Re: Cedar Apartments
541, 543, 545 Cedar SW. Albuquerque, NM 87106
Traffic Circulation Layout
Engineer's/Architect's Stamp 07-11-18 (K15-D062)

Based upon the information provided in your submittal received 07-11-18, the above referenced plan cannot be approved for Building Permit until the following comments are addressed:

AS-1.0

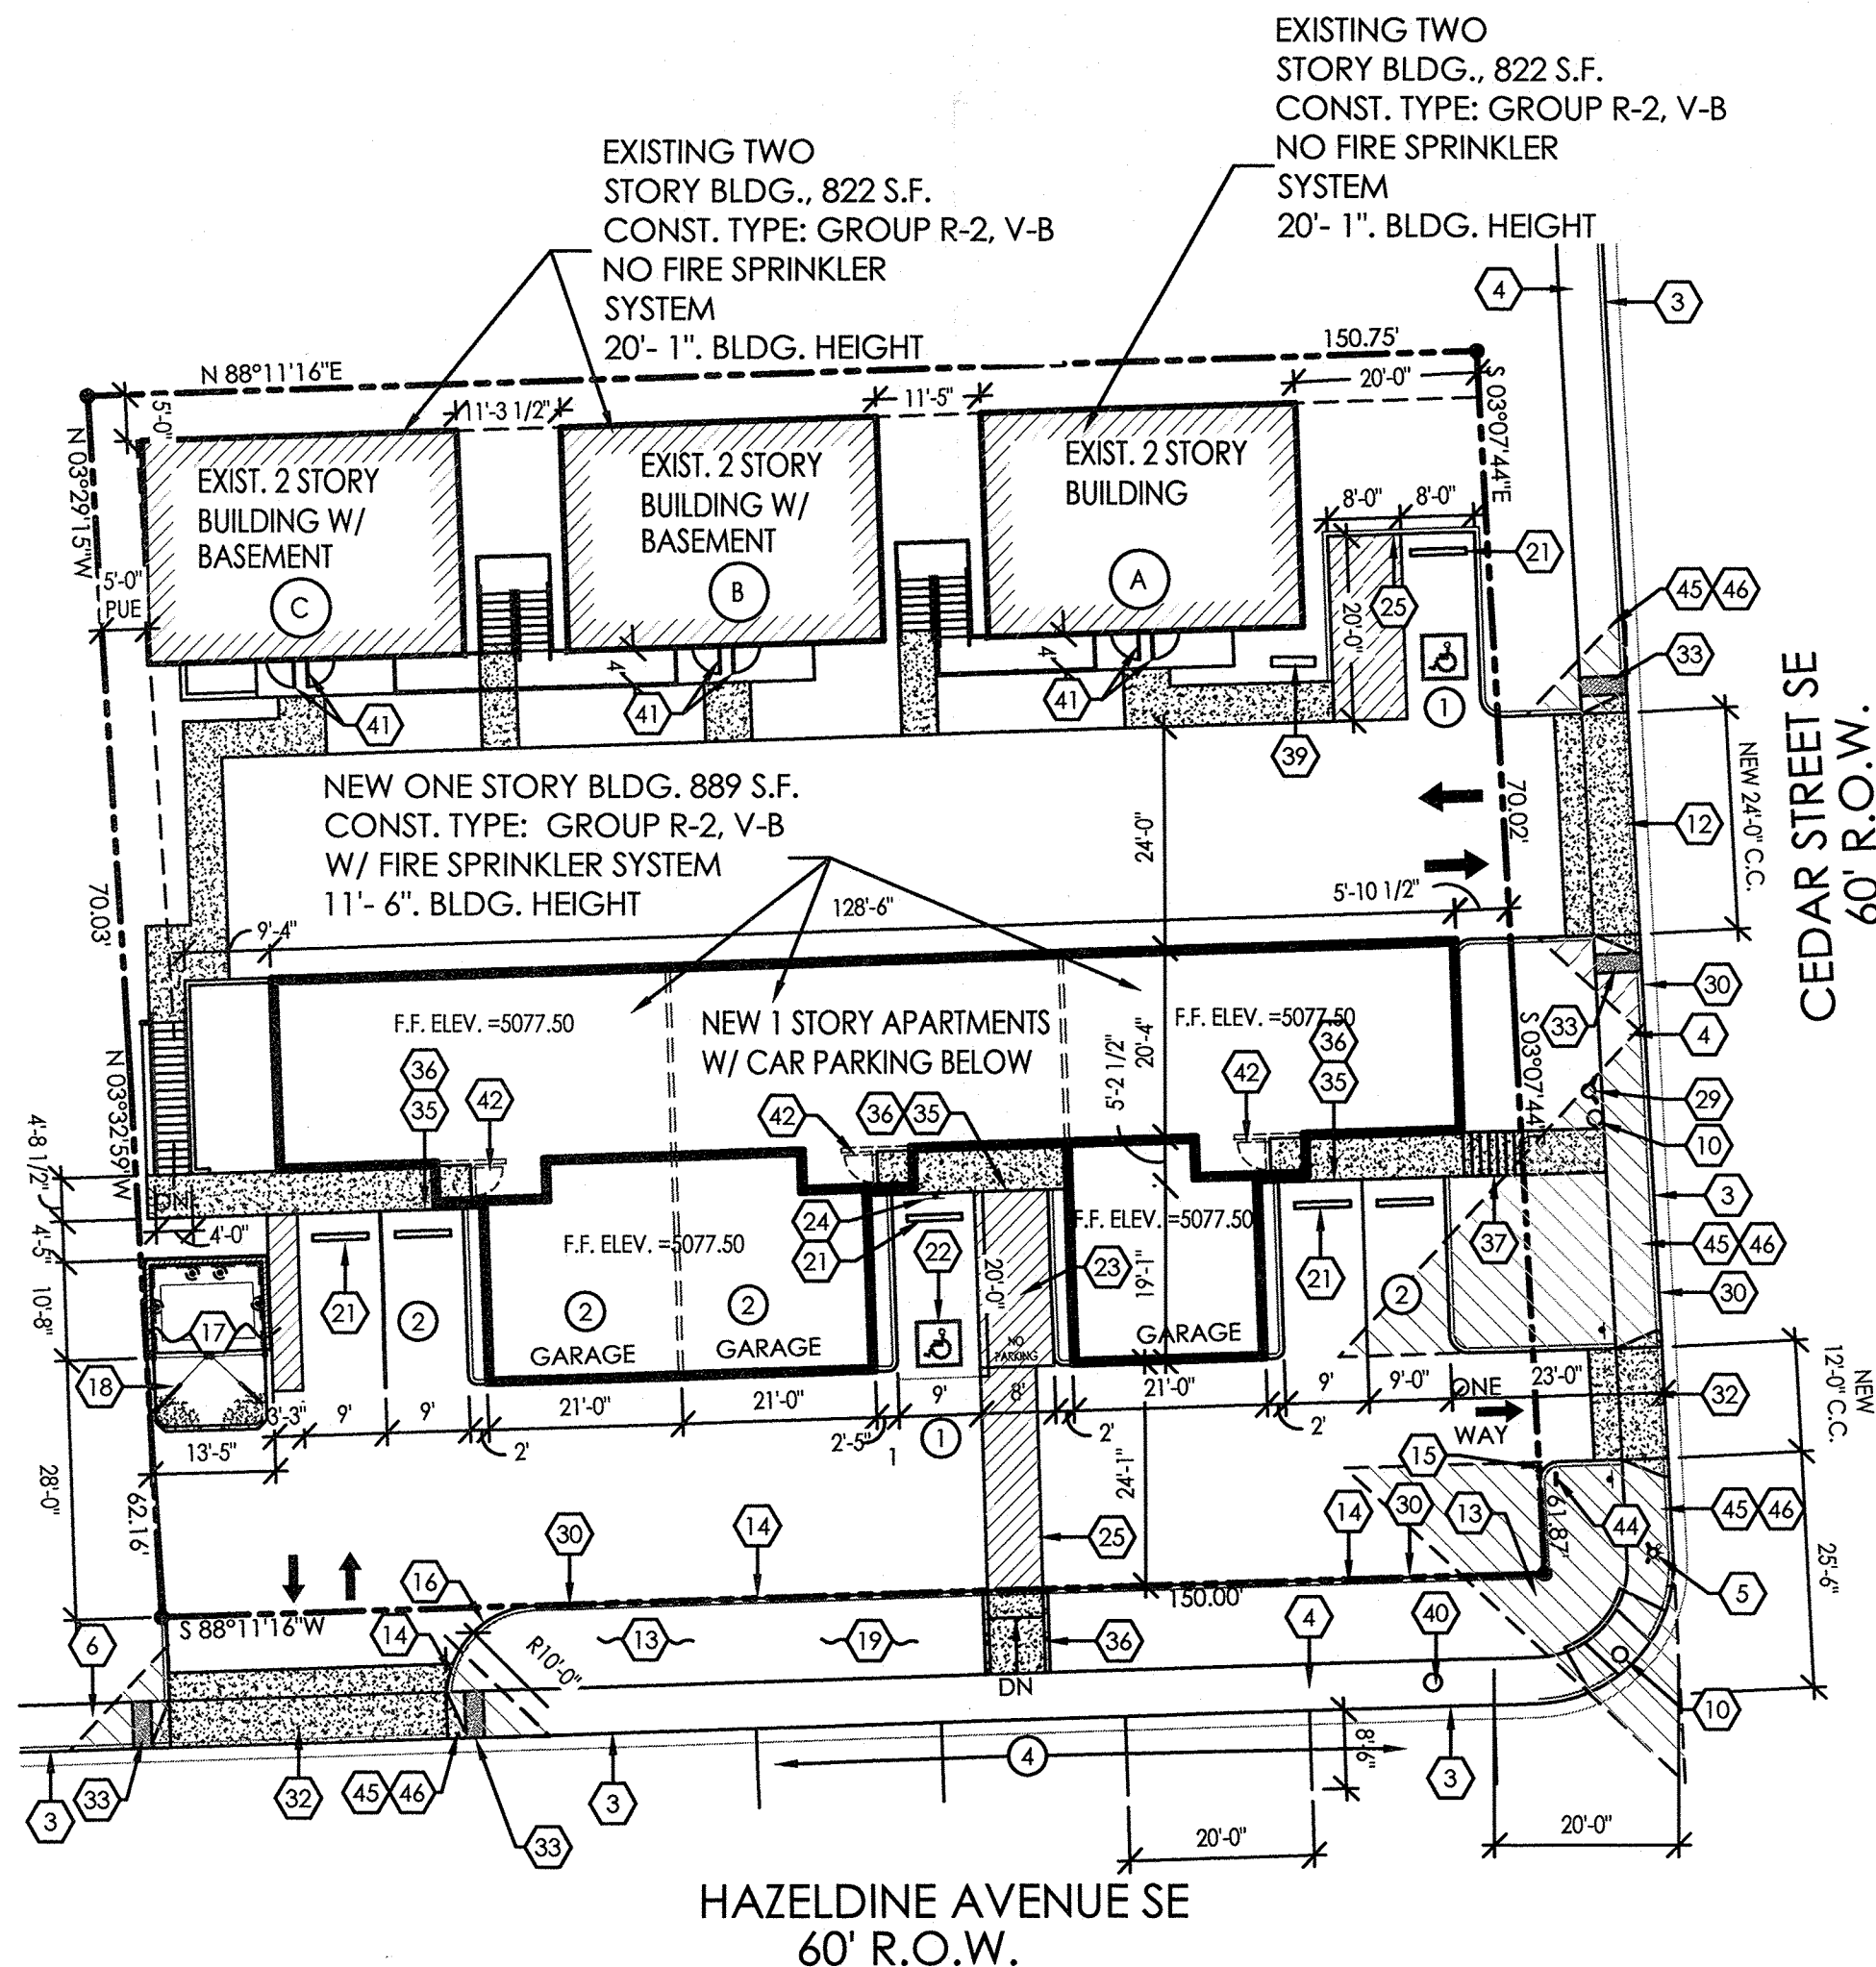
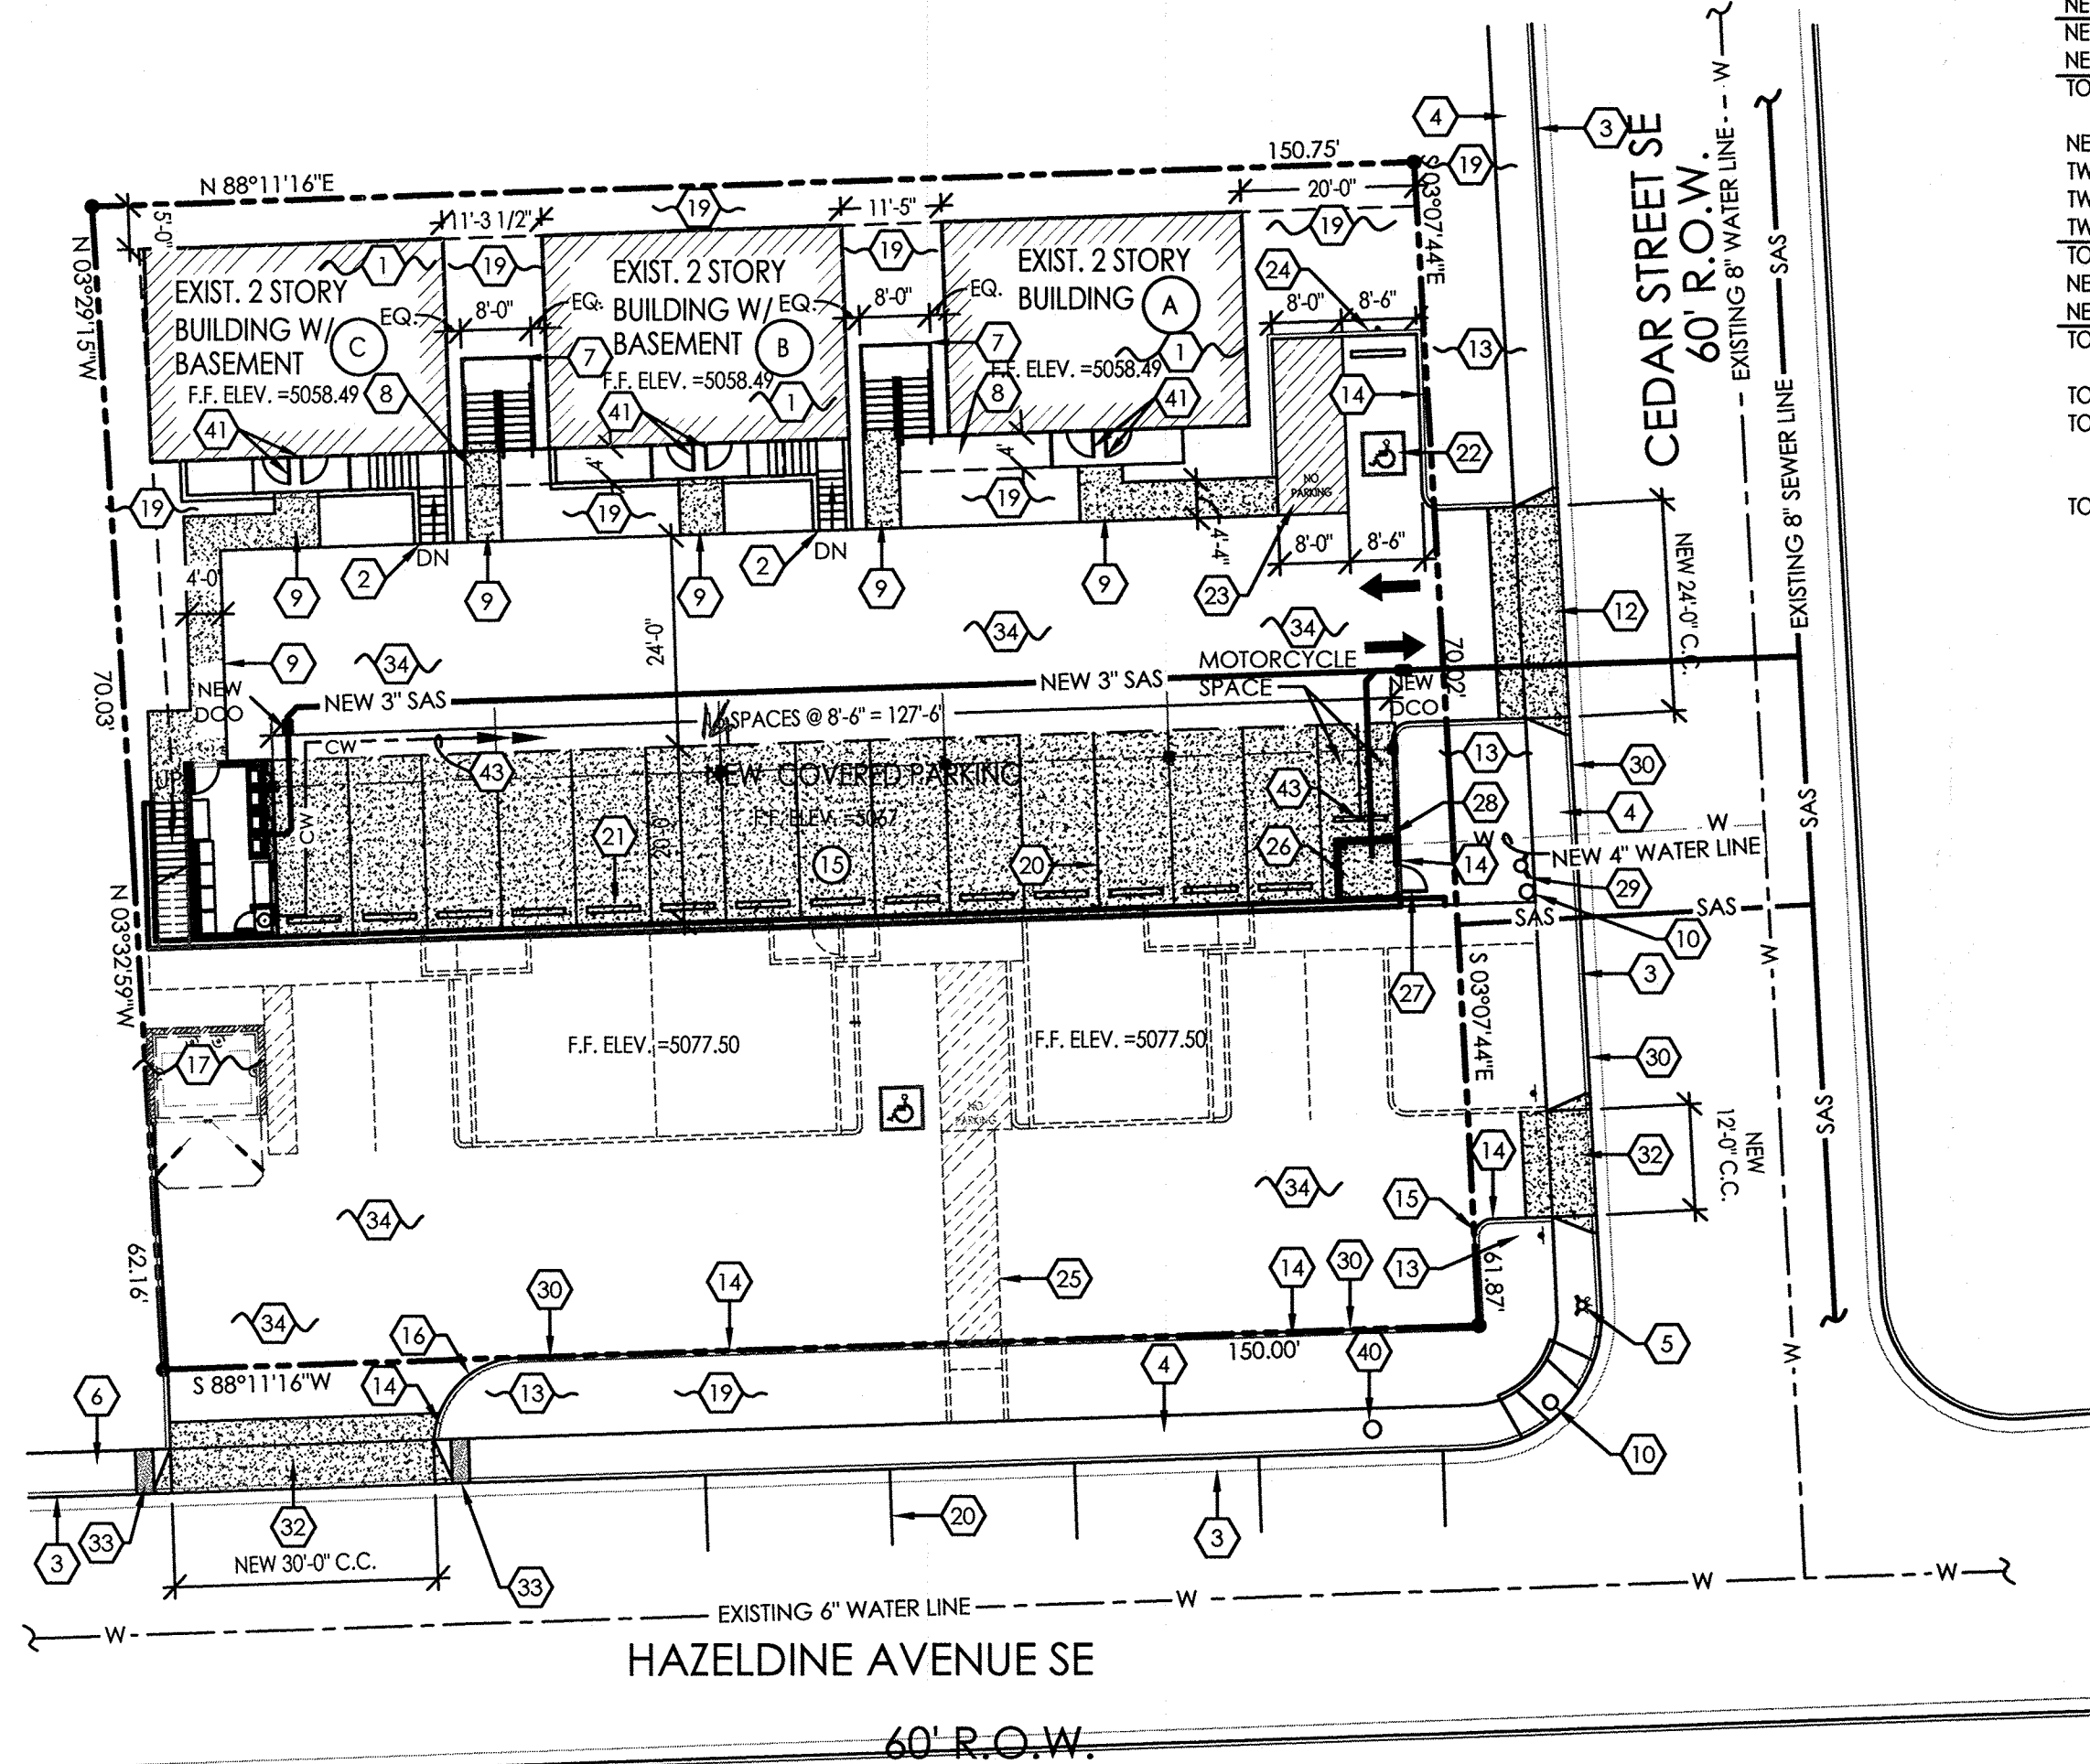
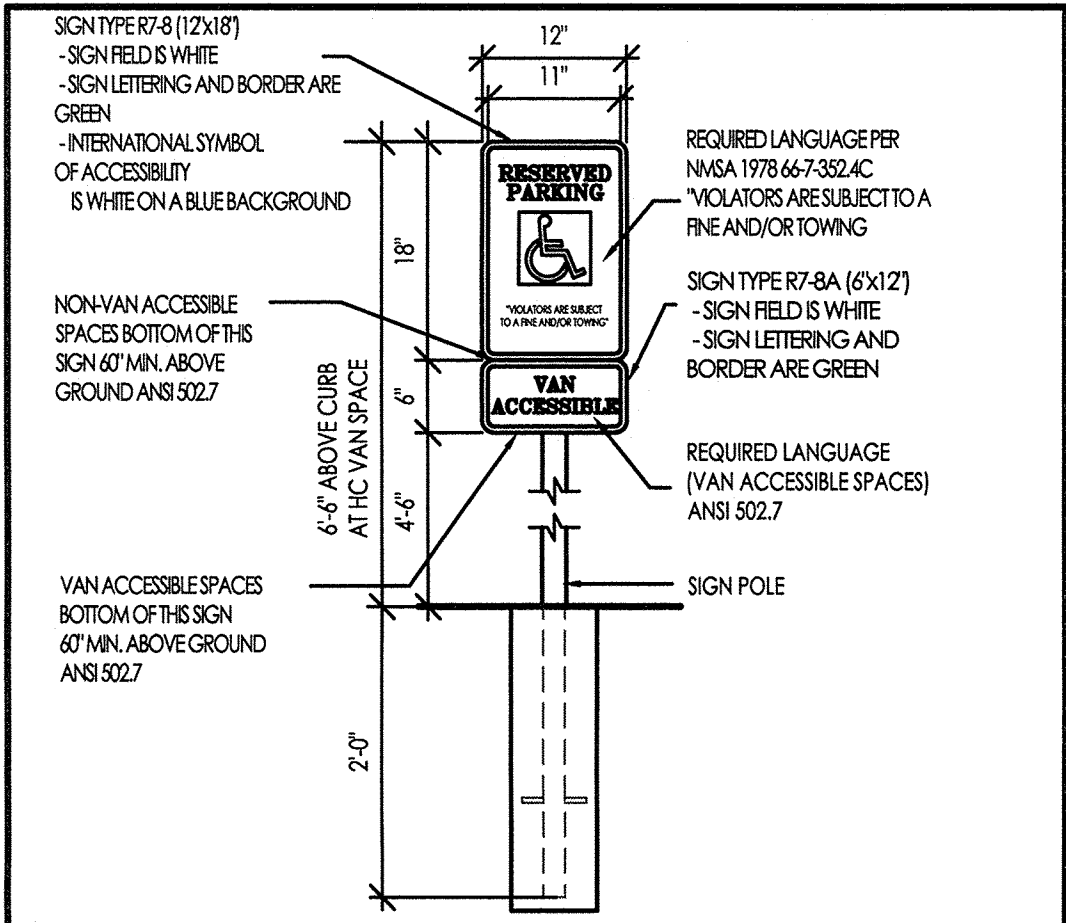
1. The total number of provided parking spaces doesn't match the number of parking spaces. 32 parking spaces is provided while 33 has been mentioned. Please correct that.

2. Please provide grading for parking and include the elevations of the building.
3. Please list the width and length for all proposed parking garage spaces. Some dimensions are not shown. The length of the ADA parking in the NE part of the property is missing. The length of the ADA parking space located beside the garage is less than 20 feet.

4. The handicap accessible spaces must include an access aisle. Van accessible aisles should be 8ft wide; all others should be 5ft wide. The Van accessible beside the garage is 6' wide.

6. Motorcycle parking spaces shall be designated by its own conspicuously posted upright sign, either free-standing or wall mounted per the zoning code.

7. Show the clear sight triangle and add the following note to the plan:
"Landscaping and signage will not interfere with clear sight requirements. Therefore, signs, walls, trees, and shrubbery between 3 and 8 feet tall (as measured from the gutter pan) will not be acceptable in the clear sight triangle."

8. The one-way exit should have designated sign.

9. Please provide dimension detail of the distances of the curb to the street parking and to the curb cut in the SE corner of the lot. The minimum required distance from the curb to the street parking is 20' and from the curb to the curb cut is 25'.

10. Please note that on street parking should not interfere the clear sight triangle.
11. Please Correct the spelling on the "Vicinity Map" as shown:

C1 HC PARKING SIGNAGE ELEVATIONS 3/4"=1'-0"

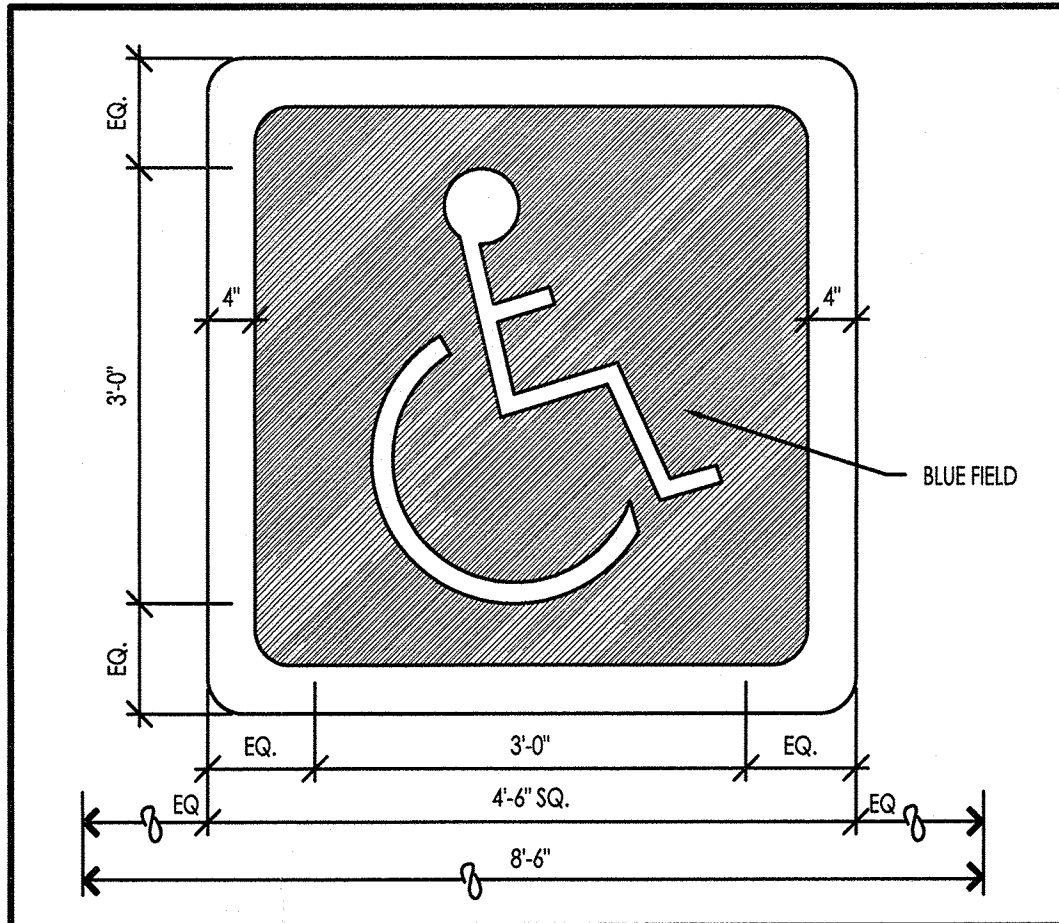
5. The ADA accessible parking sign must have the required language per 66-7-352.4C NMSA 1978 **"Violators Are Subject to a Fine and/or Towing."** Please call out detail and location of HC signs. Please include a detailed sheet.
